Please ask for: Mrs D Johnson
Email: daun.johnson@arun.gov.uk
Telephone: 01903 737762
Our Ref: BR/234/20/PL
Your Ref:
Date: 2nd October 2020

Application for Planning Permission

Development: Three storey side extension comprised of twenty nursing units linked to the existing nursing home building. This site is in CIL Zone 4 (Zero Rated) as other development.
Location: Aronel Cottage Nursing Home 5-11 Highfield Road Bognor Regis PO22 8BQ

GROUND FLOOR PLAN

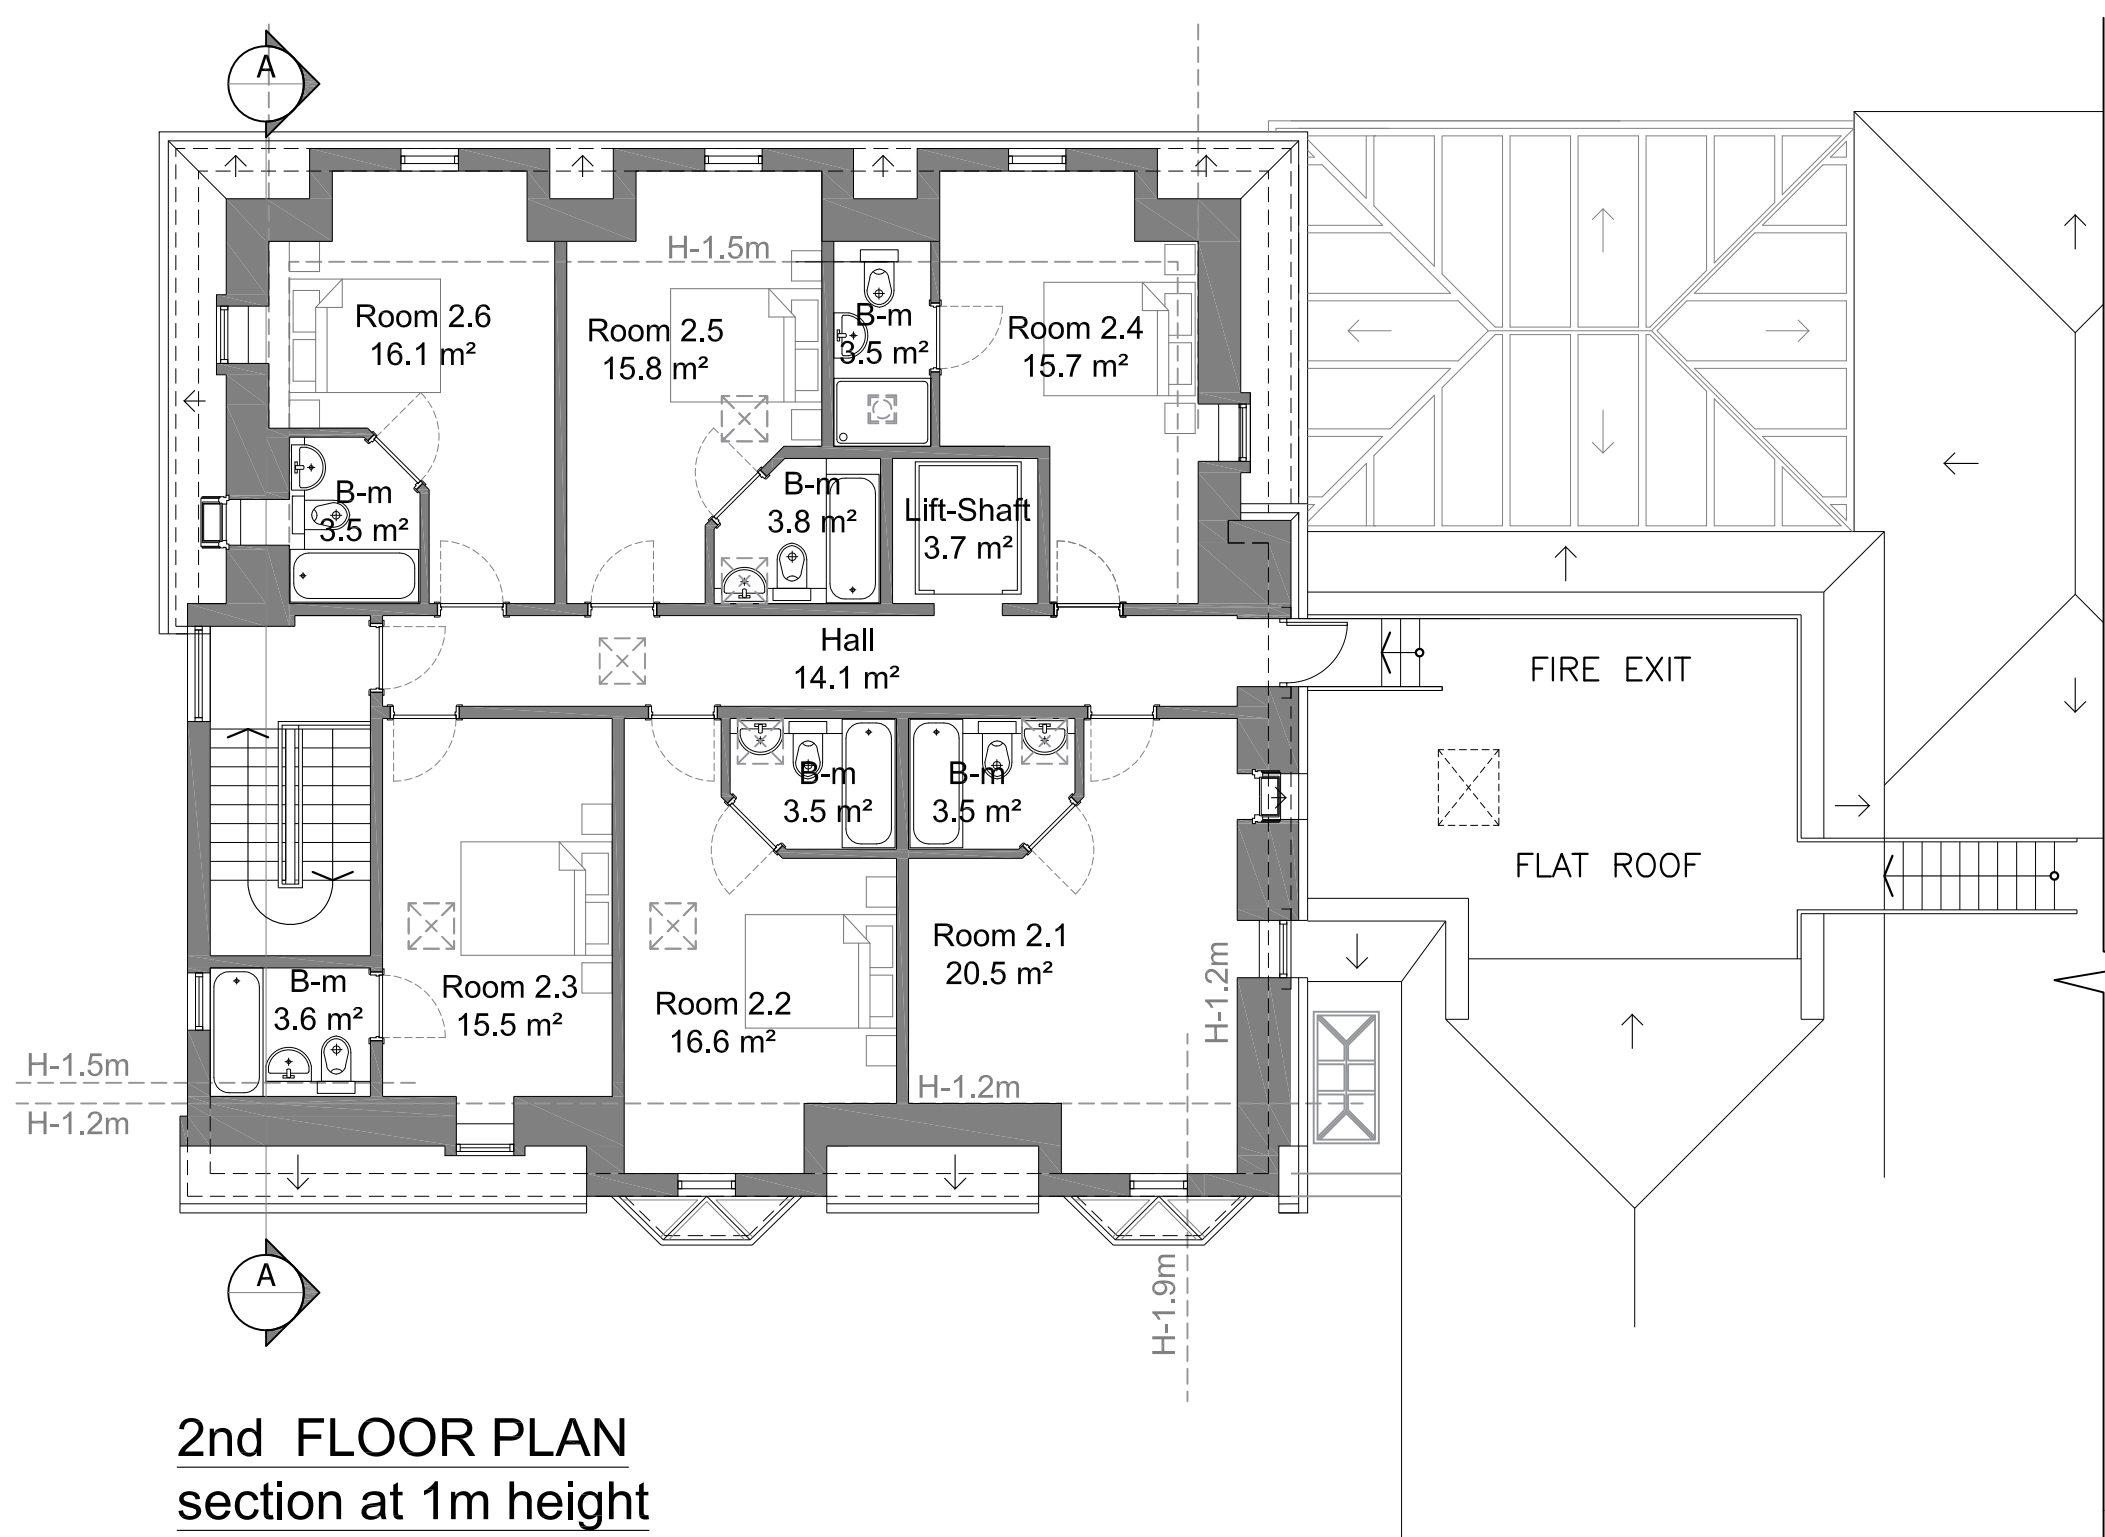
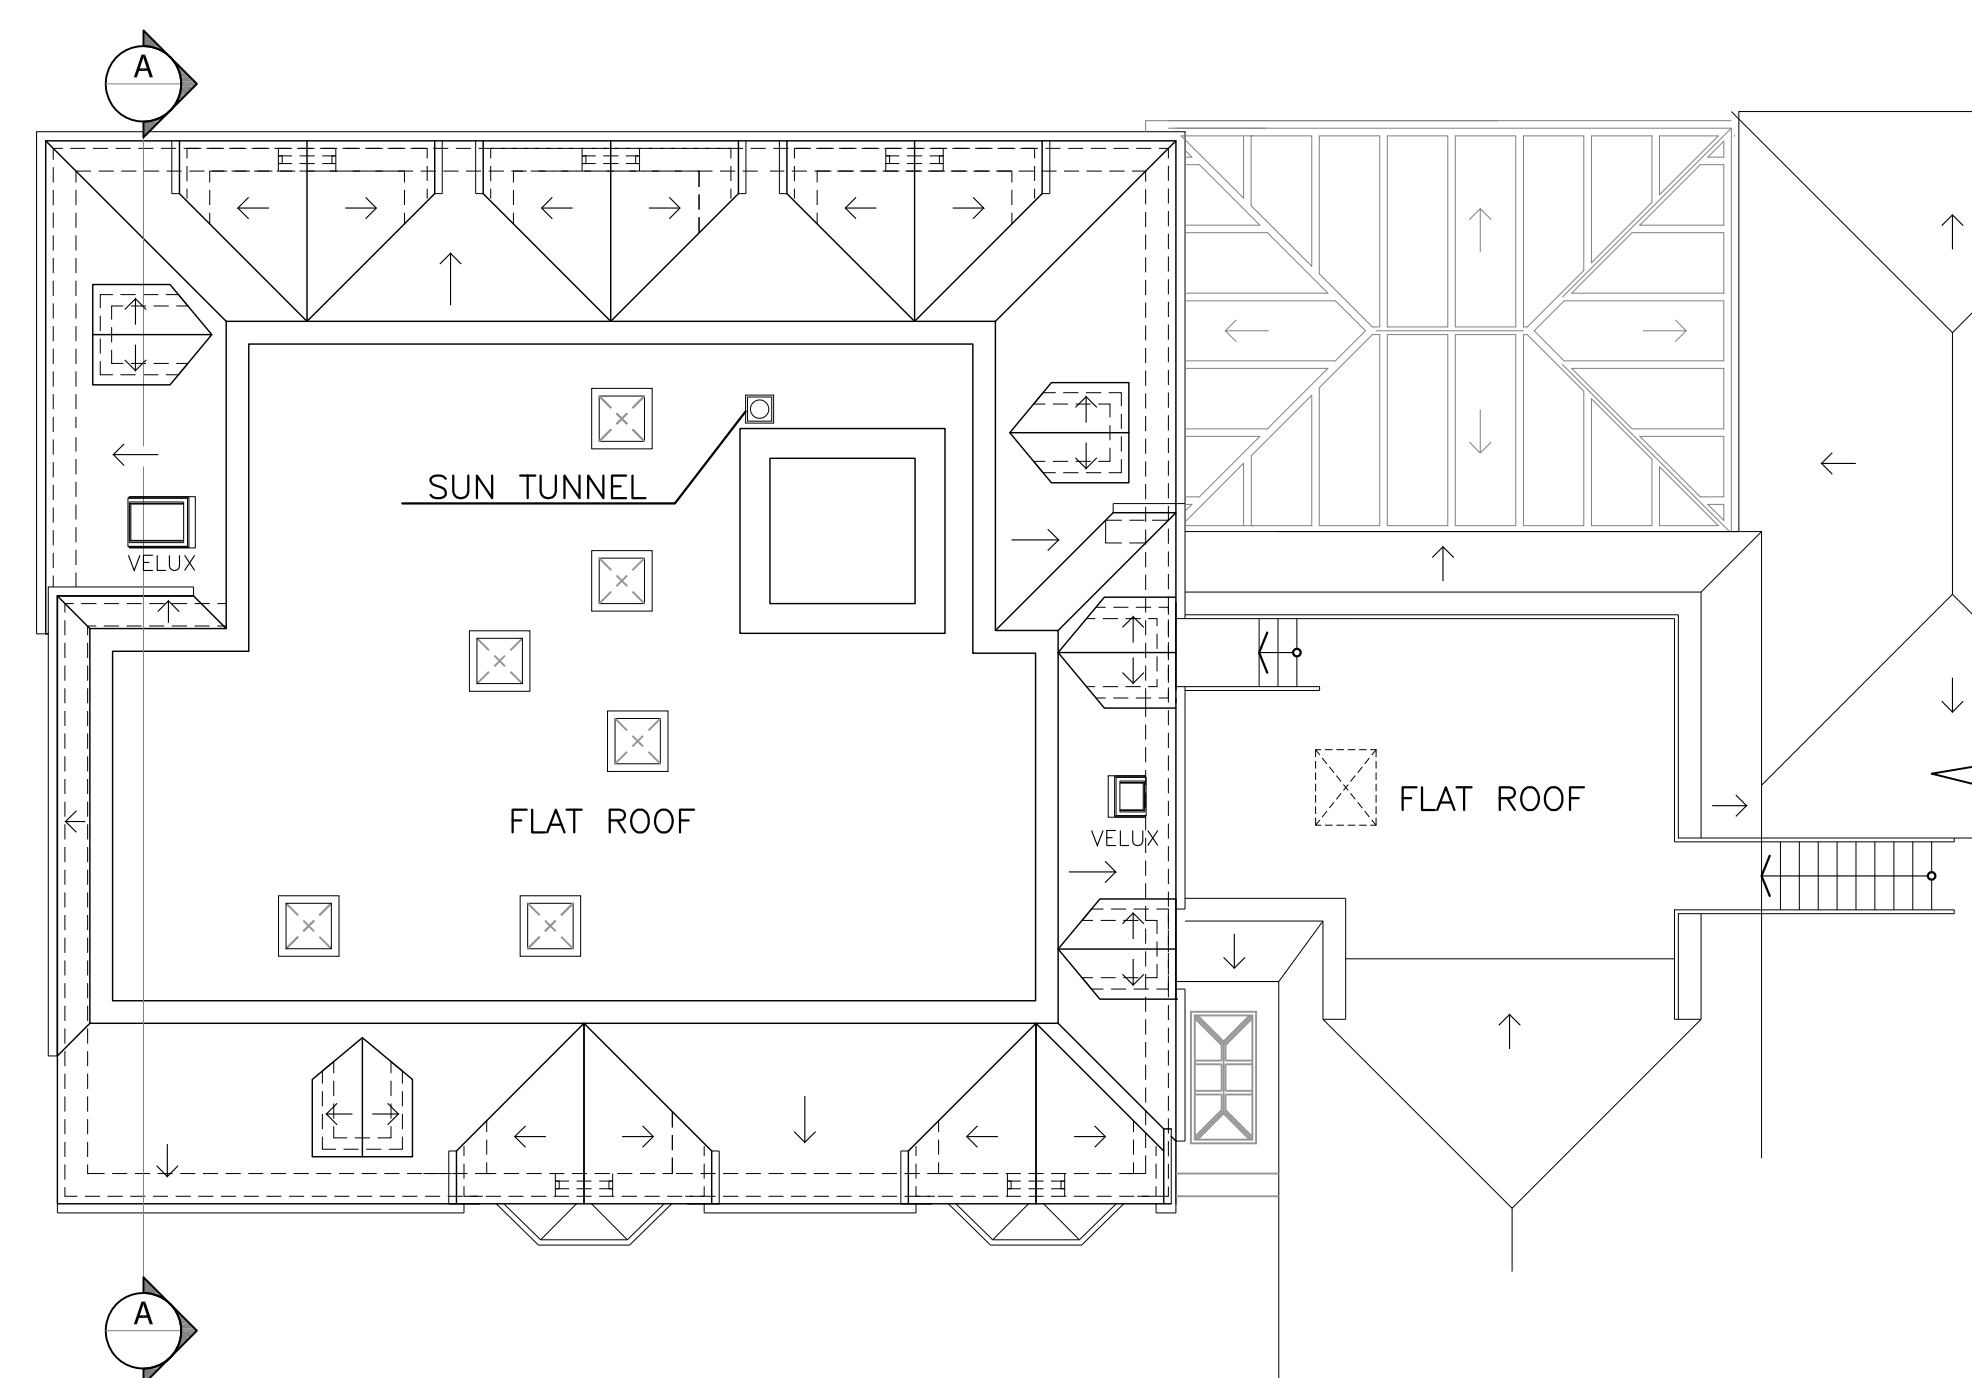
The existing ground floor plan and east elevation do not accord. Please amend accordingly.
